PROPOSED IMMINGHAM EASTERN RO-RO TERMINAL

PINS REFERENCE TR030007

RESPONSE TO APPLICANT'S CHANGE REQUEST FROM DFDS SEAWAYS UK PLC

\\ukfspp02.europe.jacobs.com\Maritime\PROJECTS\Ports\VT\B2429400-ABP-Project\Sugar\1100-Design-Engineering\1102-Drawings\01-Preliminary\02-DCO Drawings\B2429400-JAC-00-ZZ-DR-ZZ-0203-PO3.dwg - 19/10/2023 10:34:12 - 0203 - TALBOTDK

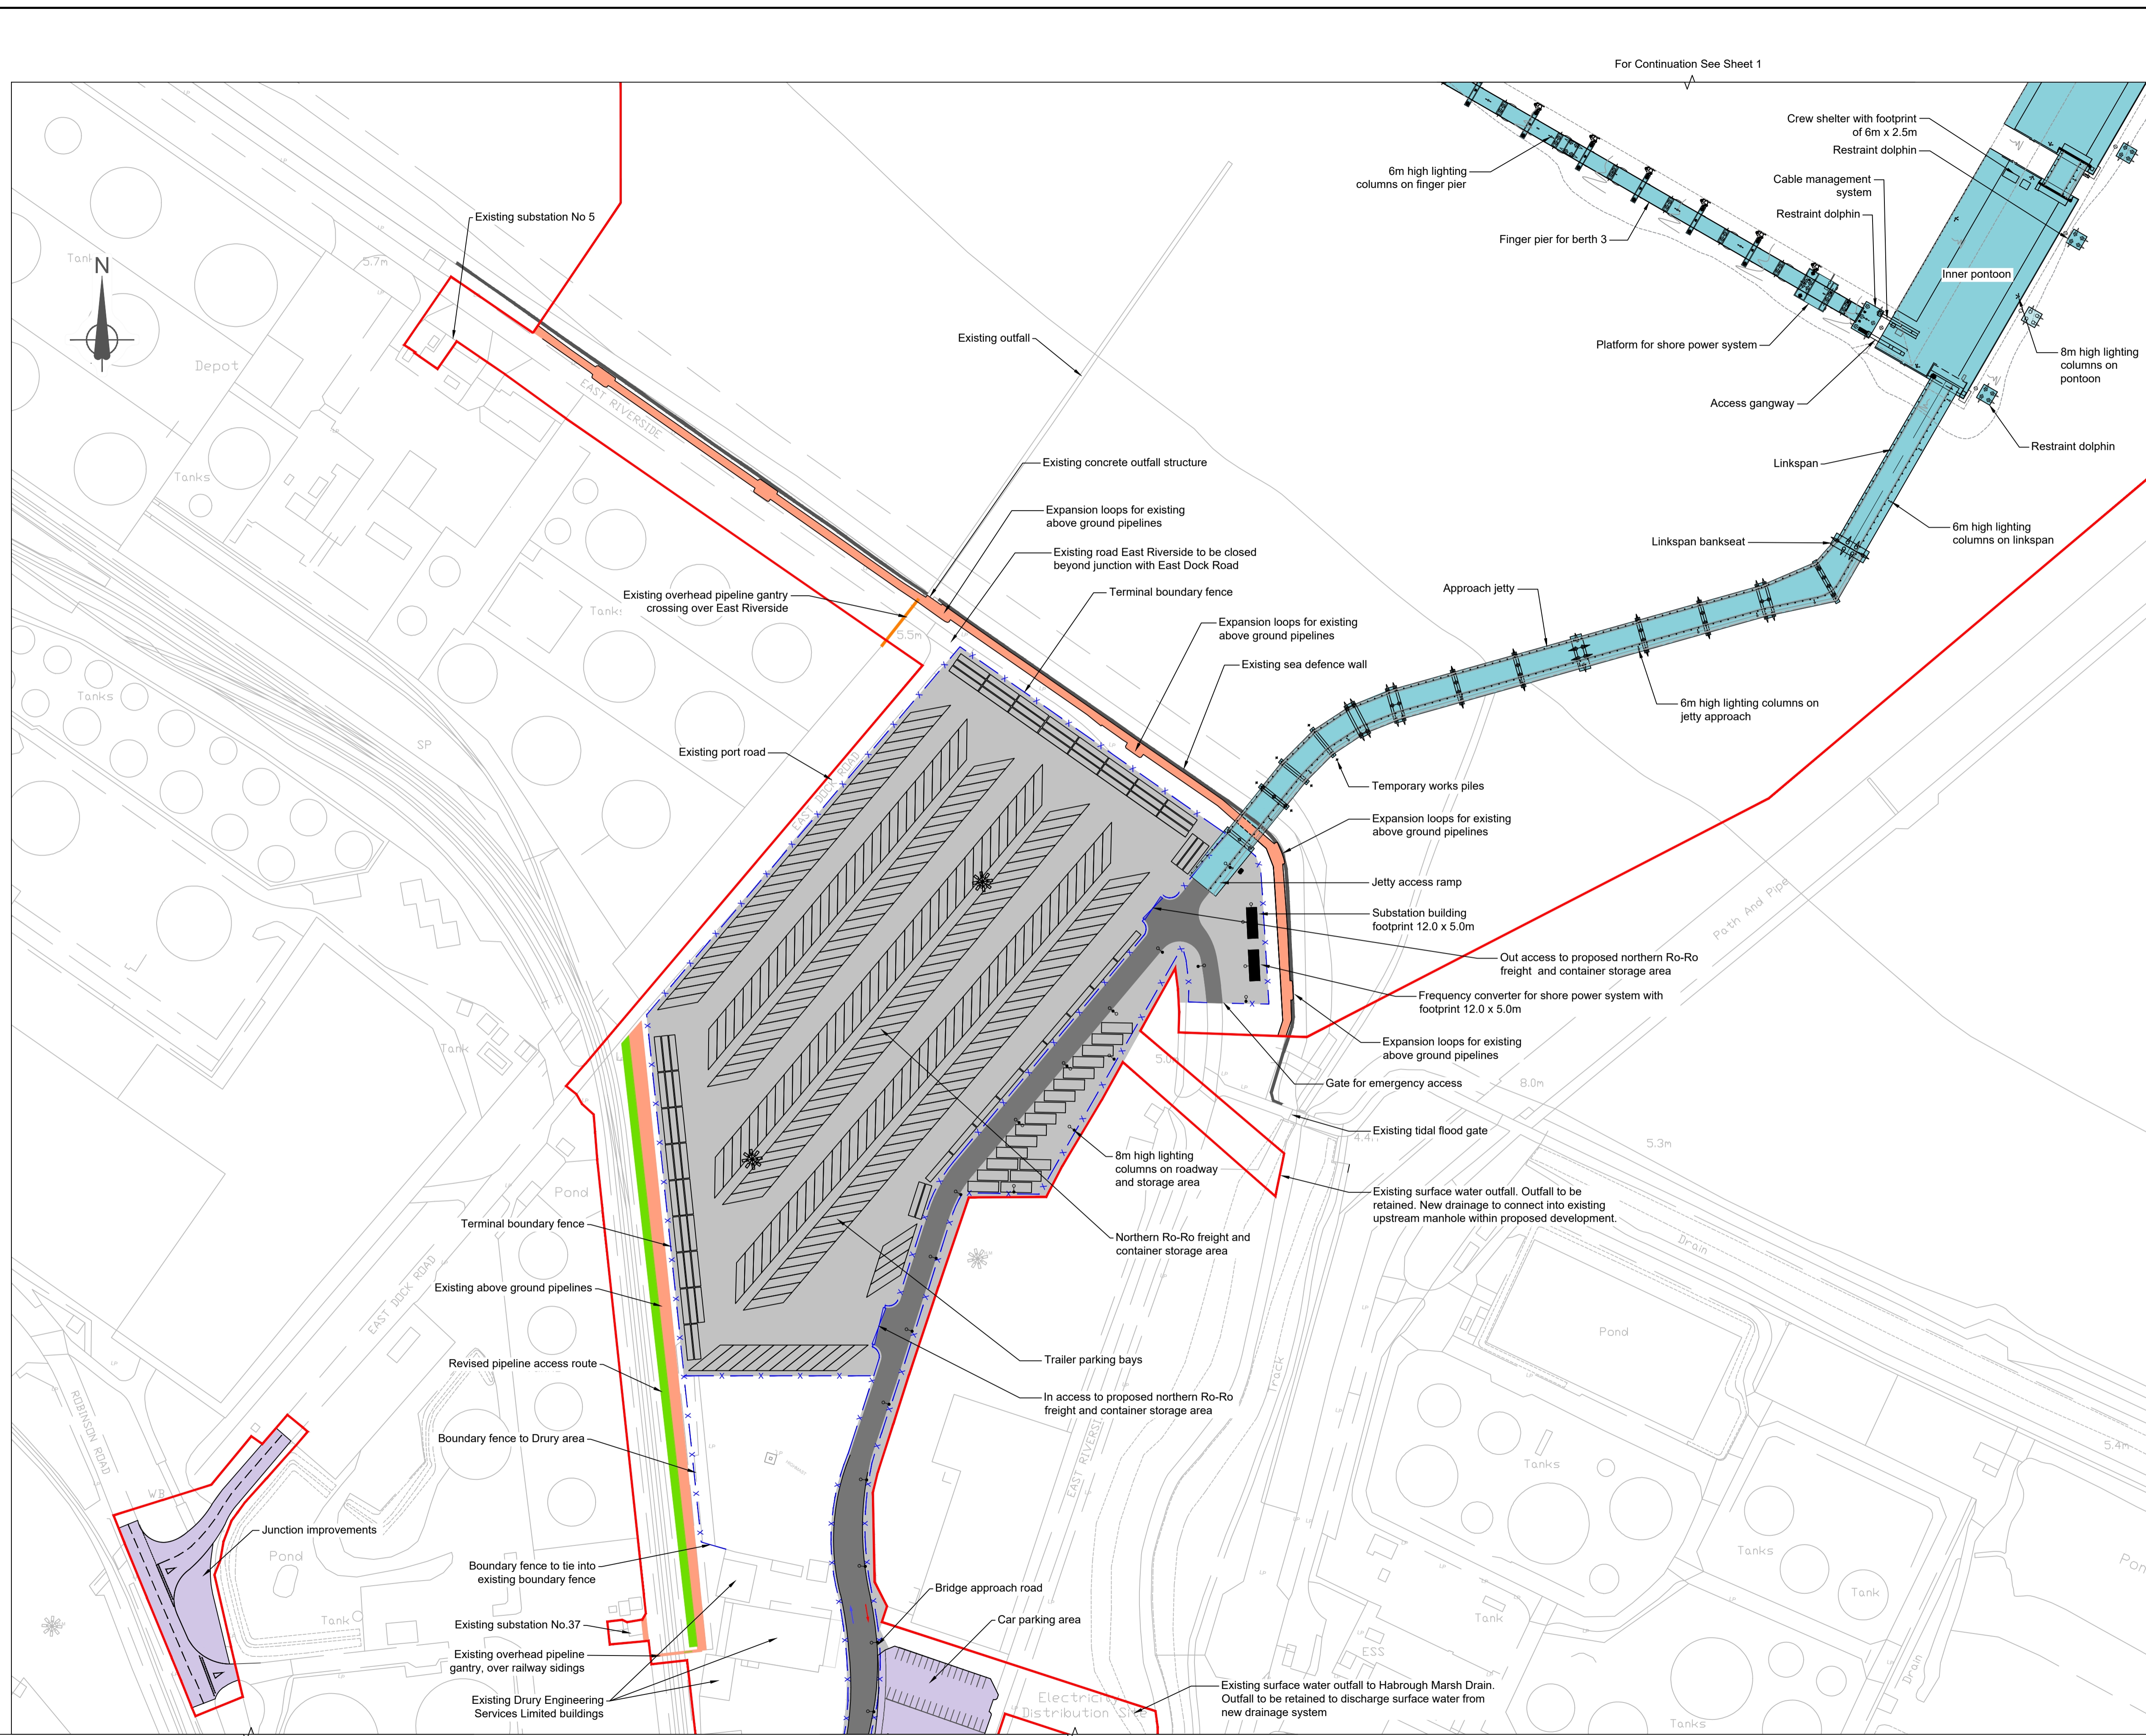
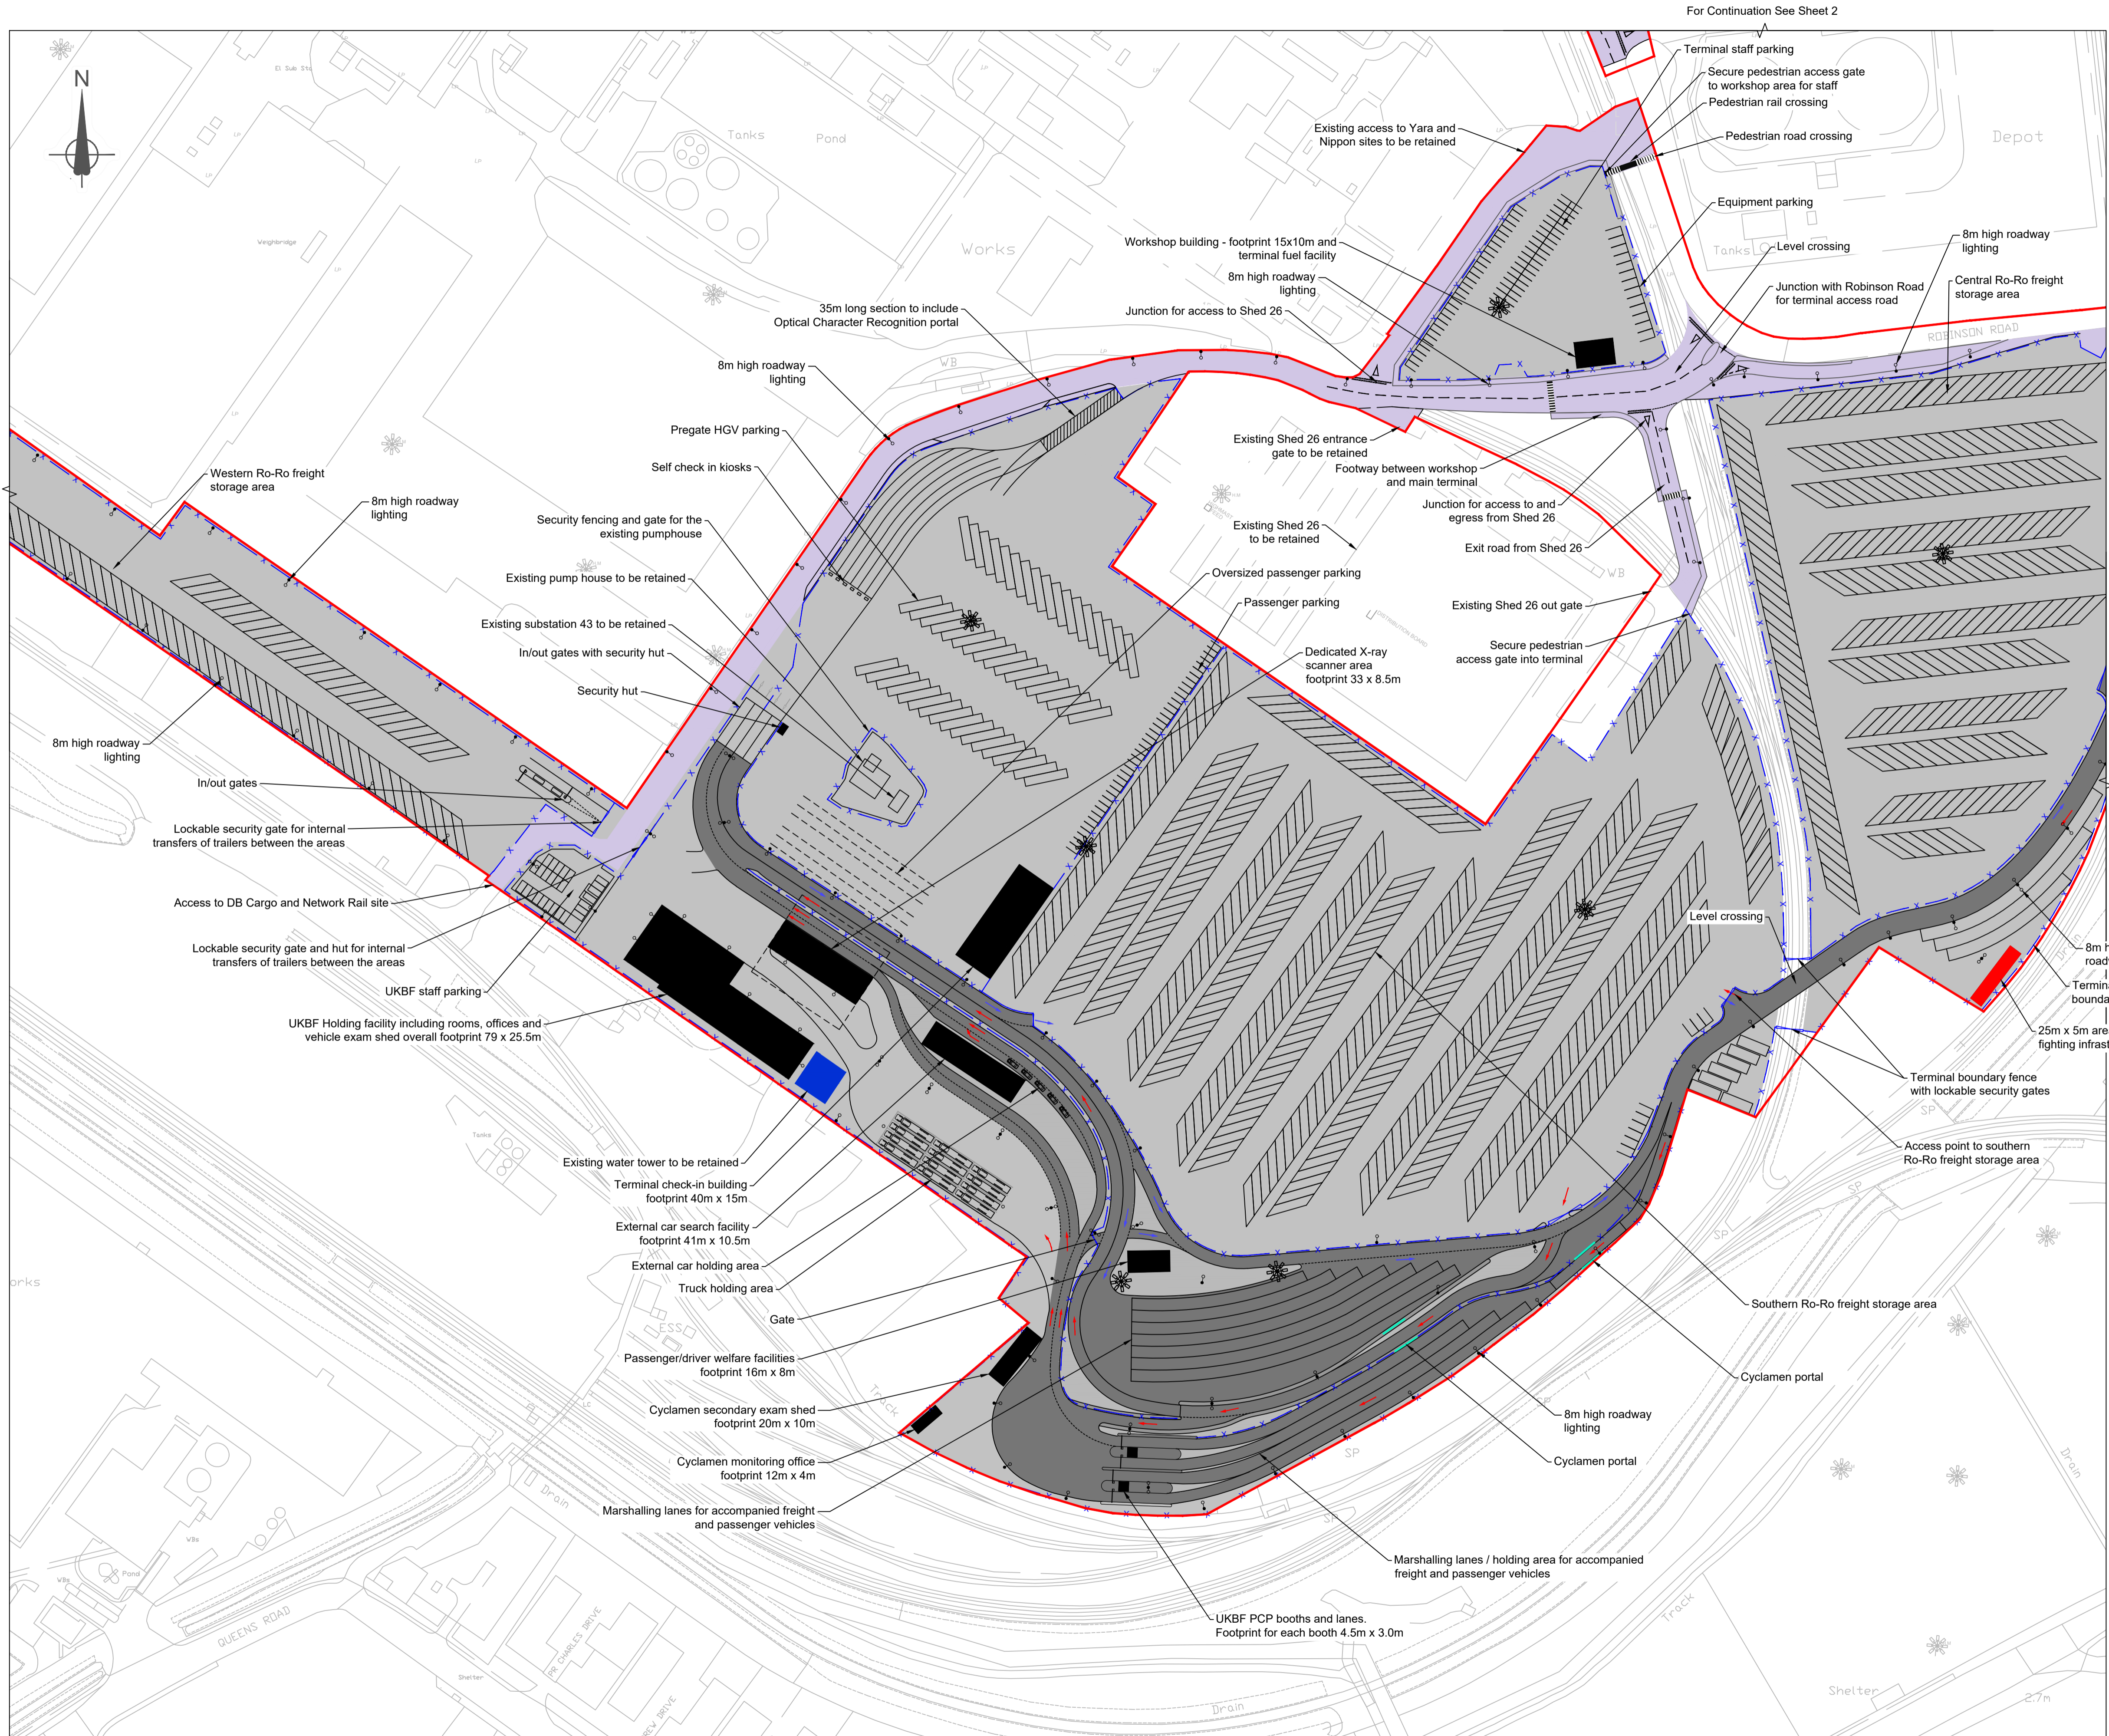
- 4.8 In the consultation version of the Environmental Statement Addendum it stated at paragraph 3.3.6 [AS-028] that there was to be a general increase in trailer spaces from 1,430 to 1,699. (3.3.6 of the ES Addendum) but no figure appears to be given in the 29 November version. The General Arrangement Plans [AS-029] and [AS-049] show the bays appear identical so presumably the total of 1,699 still stands.
